**Sent:** 23 September 2026 15:13  
**To:** DC Admin  
**Subject:** Re: planning application 2026/62/91714/E

FAO: Elenya Jackson Case Officer  
Application 2026/62/91714/E - Erection of detached dwelling, land adjacent to 7 Quarryfields, Mirfield, WF14 0NT

Proposed Site Plan
1 : 500

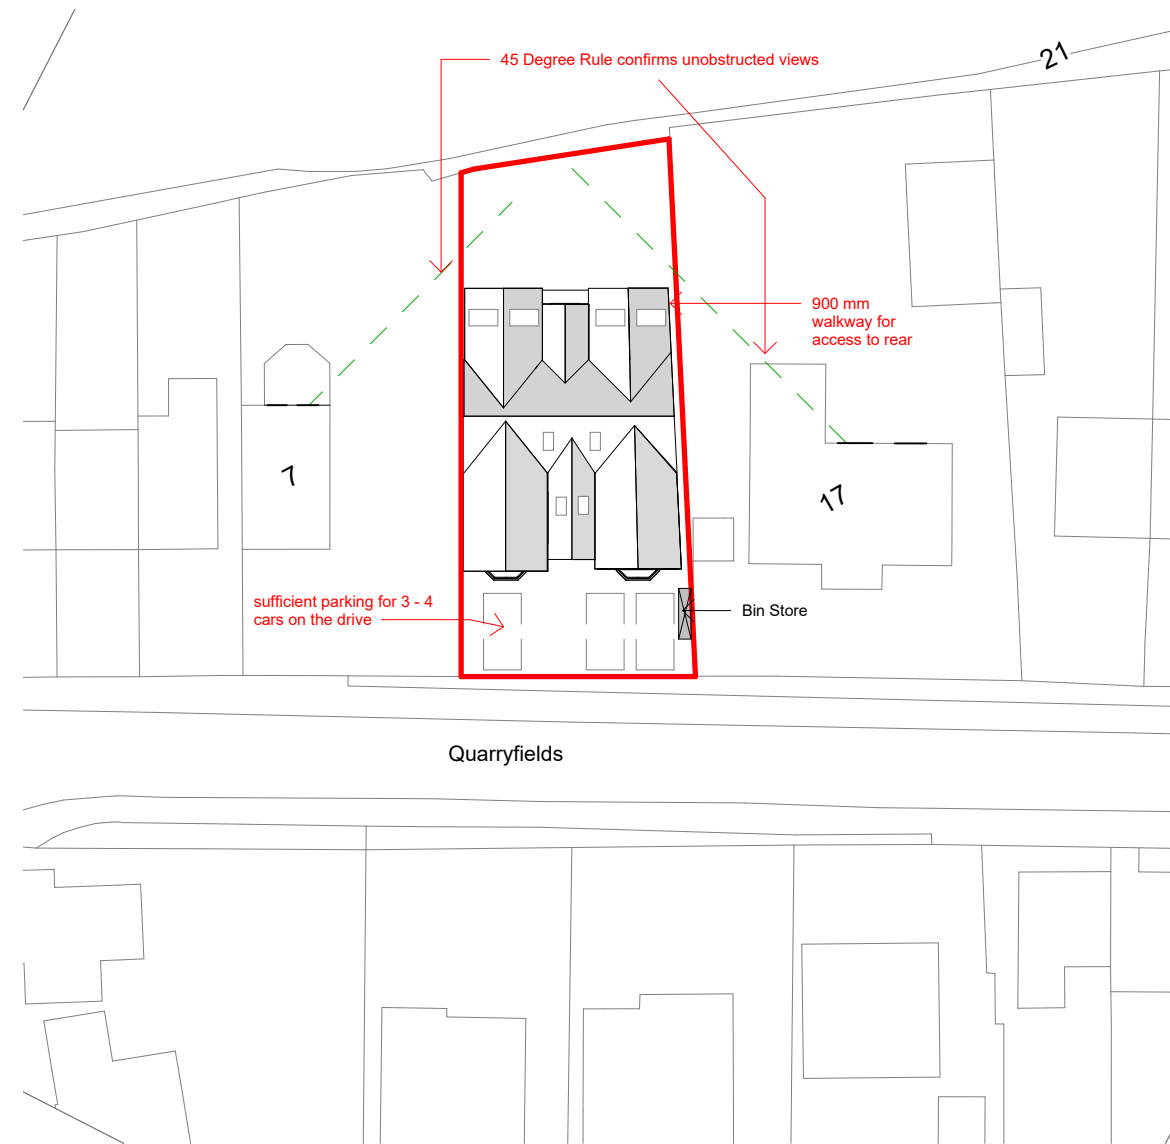
Scaling from the submitted plans, the dwelling is approximately 18.5m deep, with eaves of around 6m and a ridge of around 8.5m. Its side wall is built on the boundary with no.7 and extends well beyond the rear wall of that property. The result would be a continuous two-storey wall running along the length of no. 7's rear garden. It would be overbearing and would enclose the garden and rear rooms of no.7, contrary to LP24's requirements for a high standard of amenity for neighbouring occupiers. The 45-degree lines on the block plan do not address the impact of a boundary wall of this length and height. Furthermore, the "existing neighbour's hedge retained and trimmed" identified on the block plan does not exist; thus, the overbearing nature of the two-storey wall is even more visible.

Properties on this part of Quarryfields sit on generous plots, with clear spaces around buildings. The proposed dwelling has roughly 450-500 sqm of floor space across three levels and covers around half of the plot. It is built up to one side boundary with only 900mm to the other. The rear garden is correspondingly shallow at approximately 7.5-10m. The frontage is given over almost entirely to parking and bin storage.

Proposed Side Elevation
1 : 100

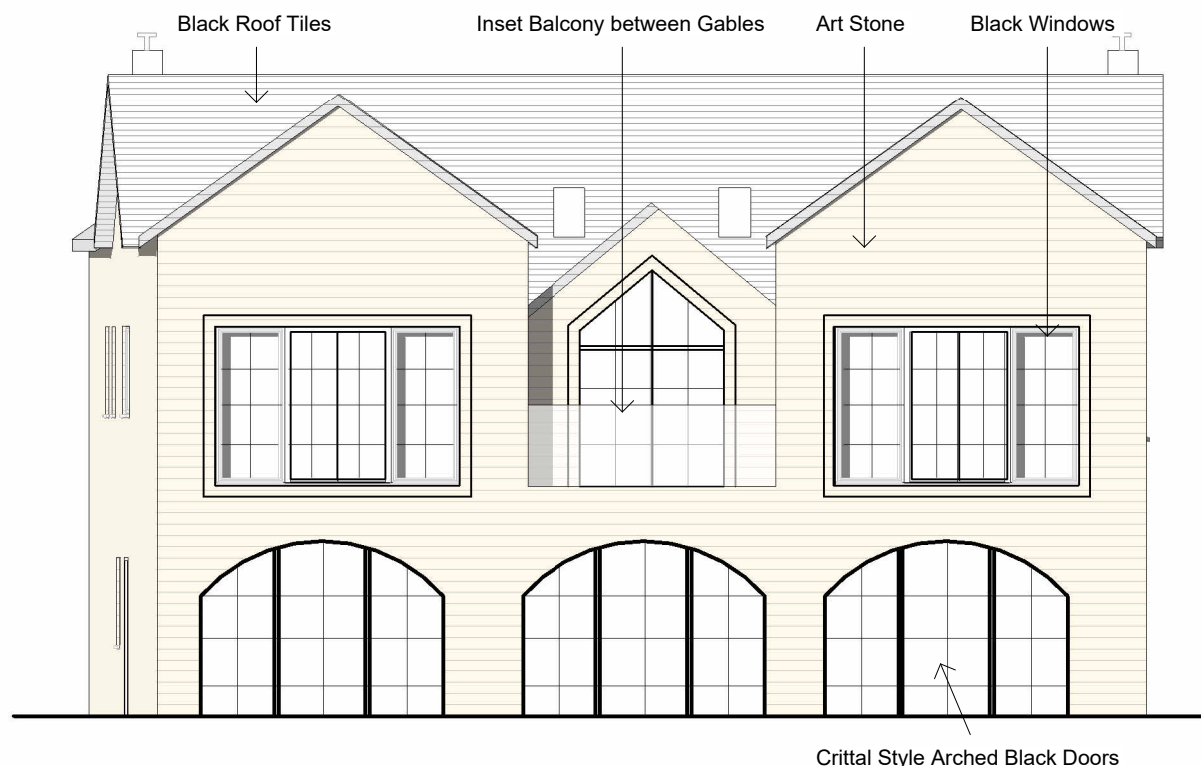
Side Elevation 2 shows first-floor windows, including an arched window, in the wall on the boundary with no.7. These would look directly onto the neighbouring property. Side Elevation 1 shows further first-floor windows facing no.17, around 5m from that property across a 900mm path. The application does not show that the Design Guide's separation standards are met. If the Council is minded to approve, all side facing first-floor windows should be obscure glazed and non-opening below 1.7m.

Proposed Side Elevation 2
1 : 100

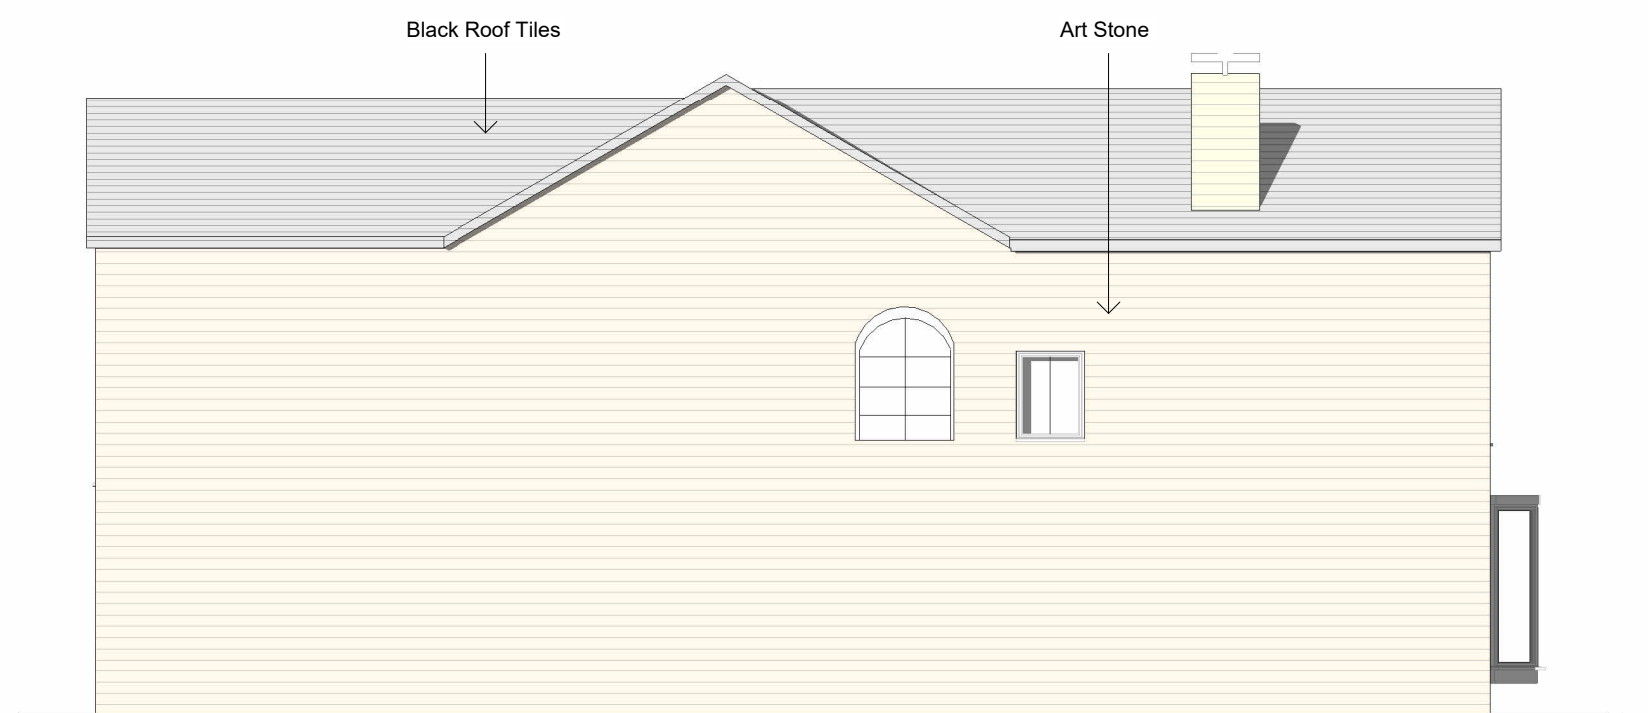
The dwelling projects well beyond the rear building line of both neighbours. The rear balcony and large first-floor rear windows would therefore give direct angled views into the private rear gardens of nos 7 and 17.

This amounts to a cramped plot-to-building ratio that fails to respect the scale, layout and spacing of surrounding development, contrary to LP24. The prominent gables, double-height glazed atrium and three full-width arched rear openings add further to the bulk. NPPF paragraph 135 required development to be sympathetic to local character, and paragraph 139 states that development which is not well designed should be refused.
